Town & Country Planning Act 1990 (as amended) s211 Notice

Surgery to various trees within the Arundel Conservation area
Garden R/O 6 Bakers Arms Hill Arundel

Planning Ref: AB/128/13 - Land to the rear of 6 Bakers Arms Hill

Site Plan Trees
Scale 1:100

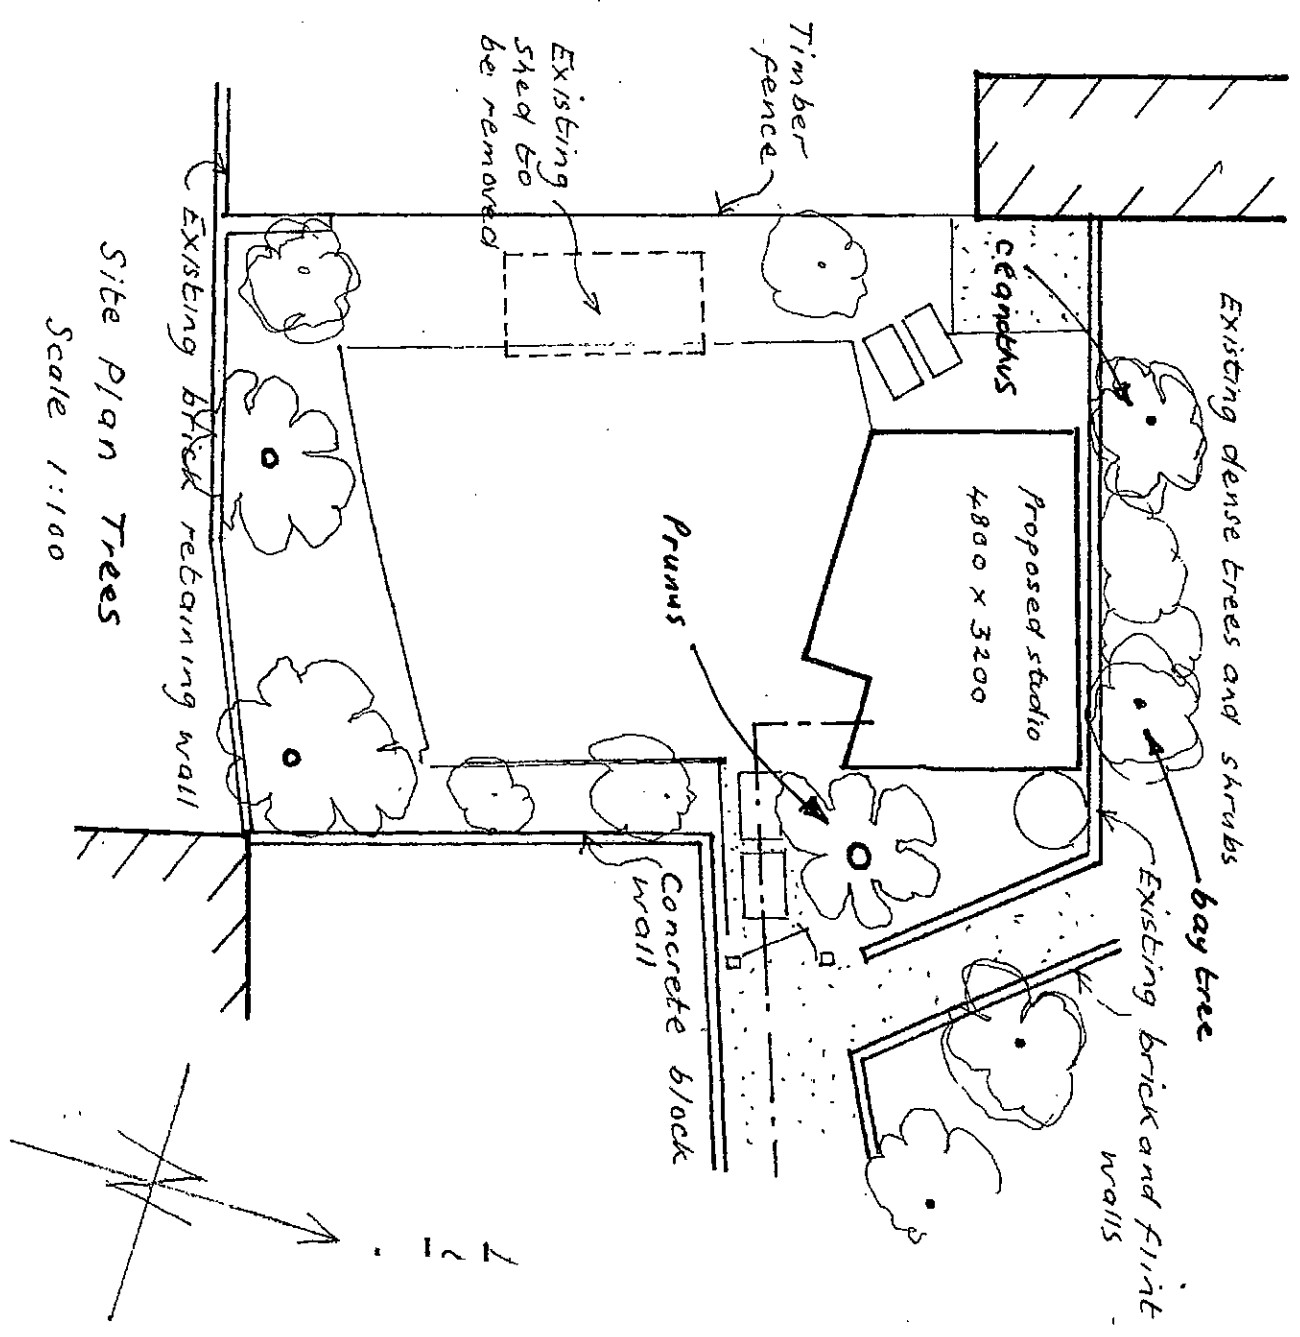
This land is first and foremost listed; therefore I believe that this is not the correct application and should be a listed planning application. I feel that the design for this studio is not in keeping with the surrounding properties. The plan with the tree and shrub locations on is incorrect, trees have been added and some not present, and the studio will be highly visible from The Cottage.
